CITY OF PORTLAND

April 16, 2004

RE: 961 Forest Avenue – 142-B-001 – B-2 Zone – permit #04-0301

C.J.'s Place  
 Pub + Restaurant  
 963-967 Forest Ave  
 Portland, Me. 04103

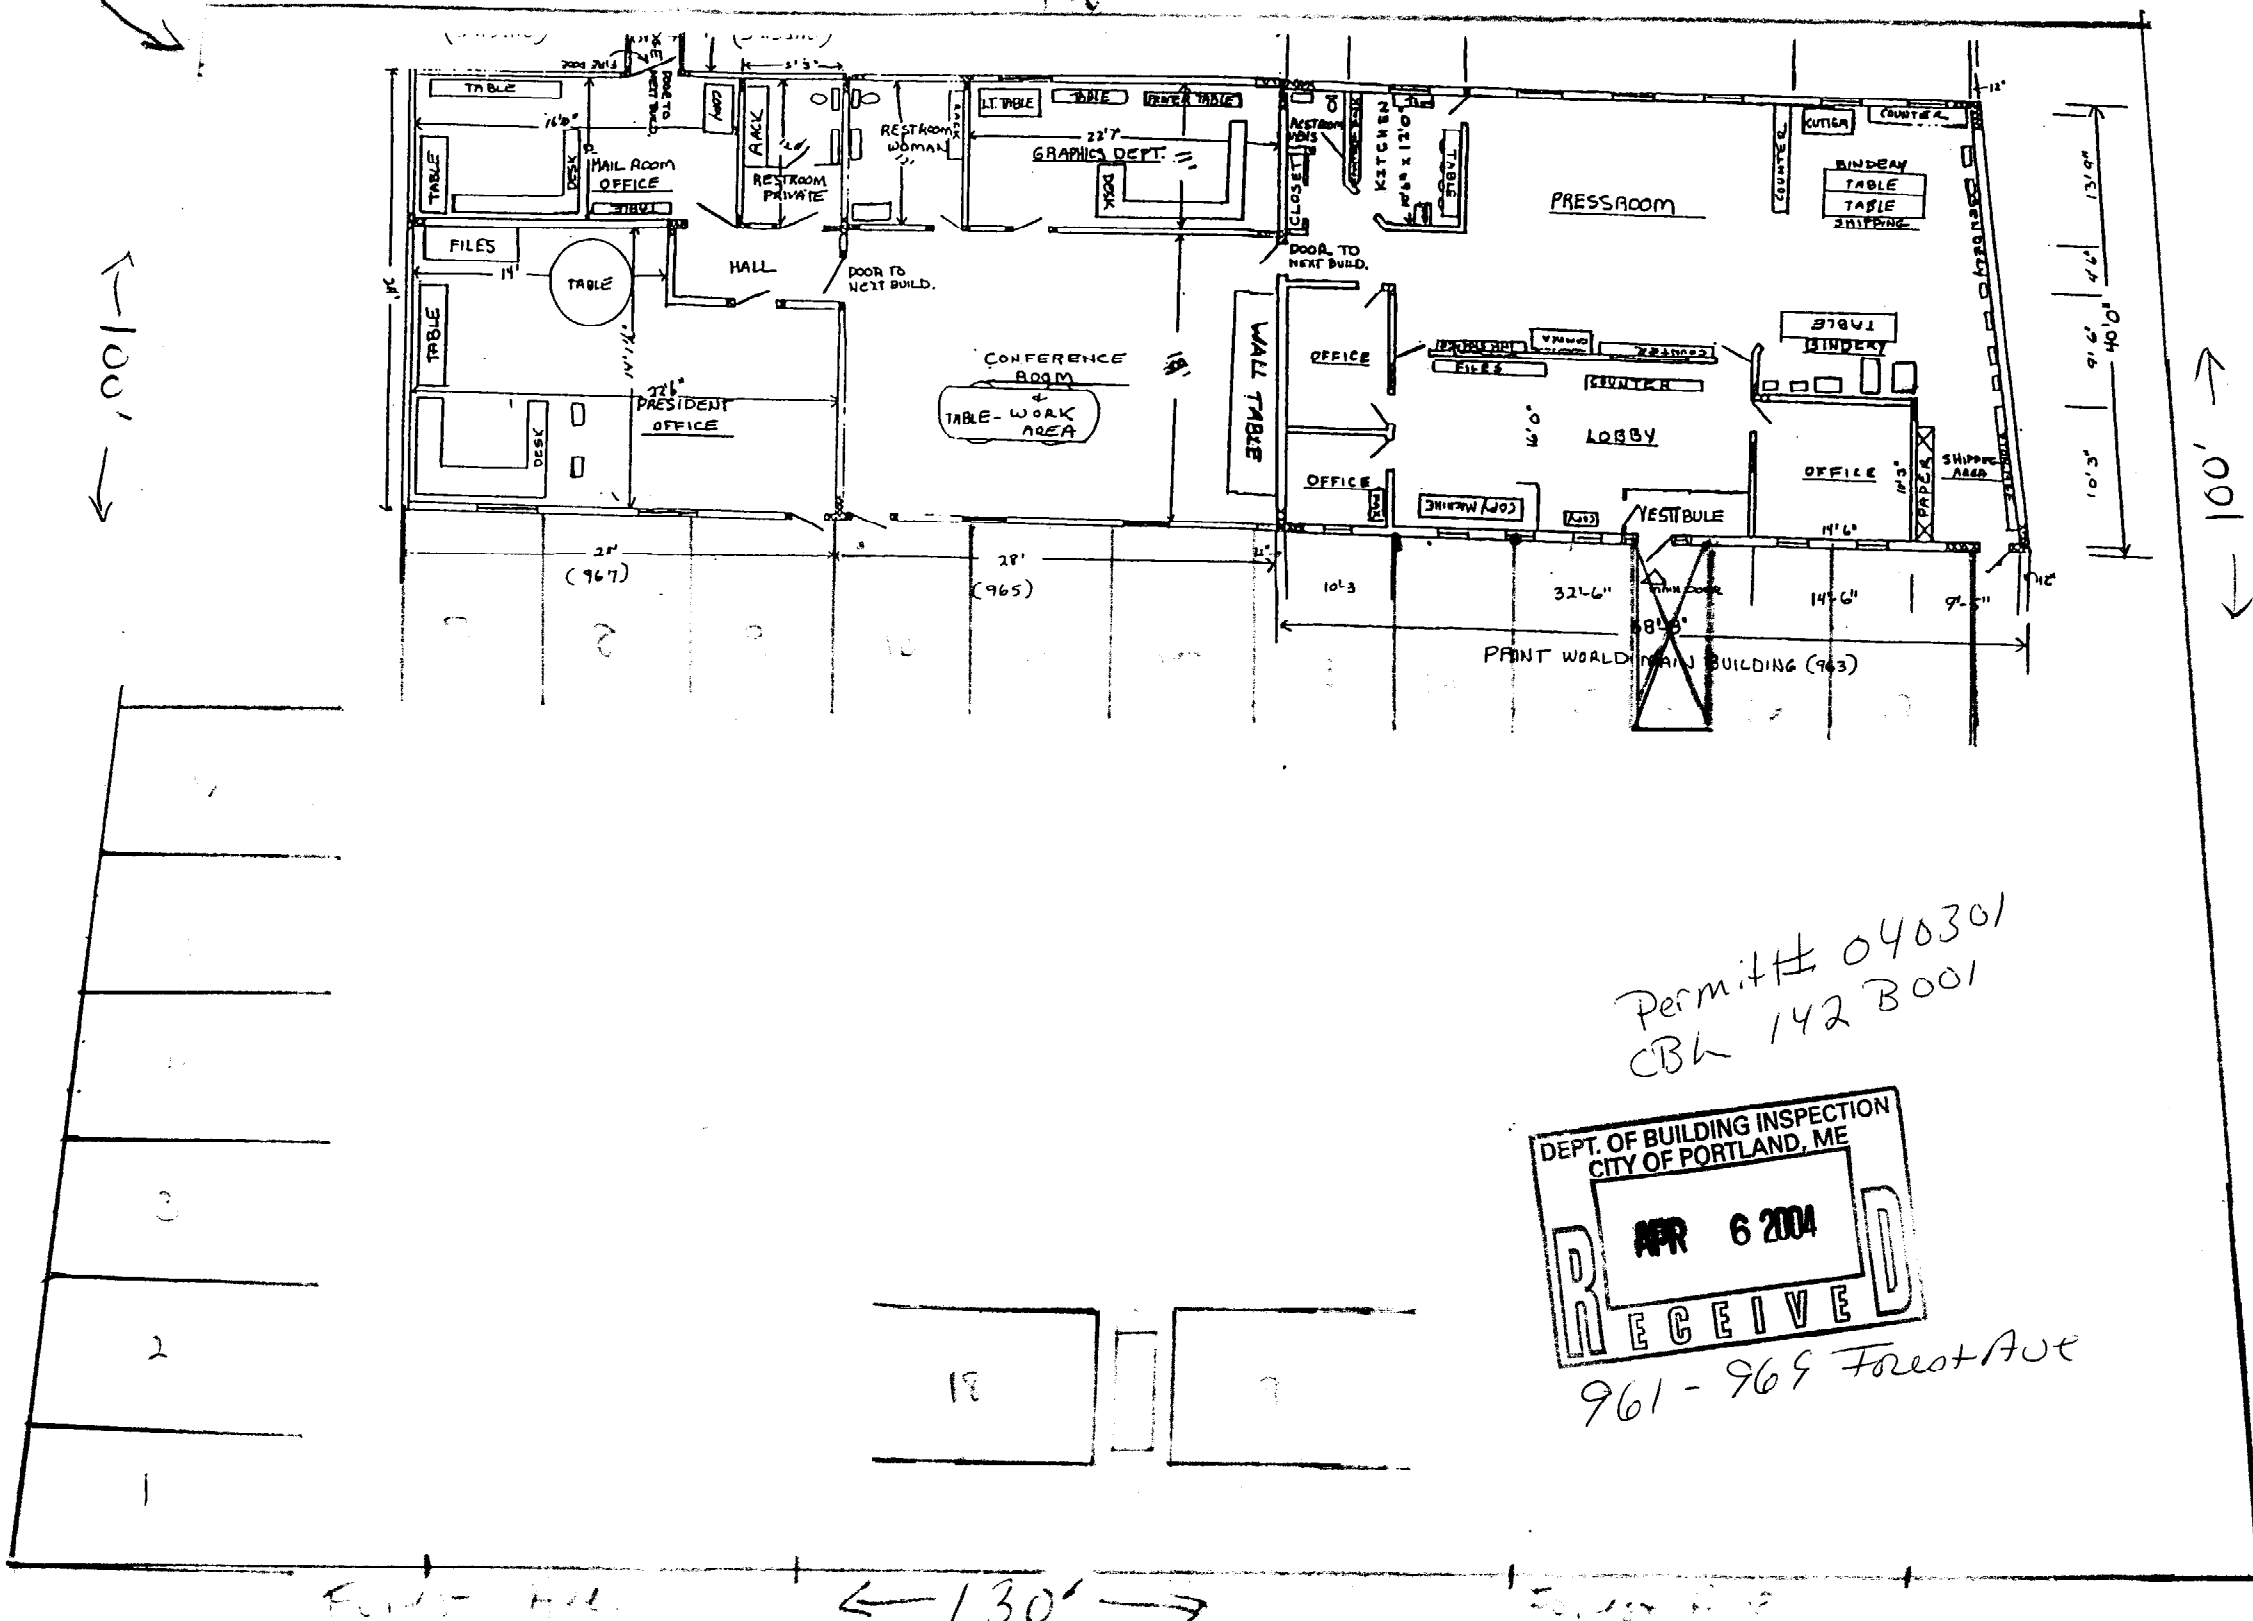
I am including the section of the ordinance (14-339) that requires you to install curbing for your parking spaces that are within 10 feet of the street line. As we discussed on the phone, your submitted plans show three spaces that are affected by this ordinance; space #1, 18, & 19.

The required curbing shall be in place PRIOR to any temporary or permanent occupancy permit. All other conditions placed on your permit also apply to your permit request.
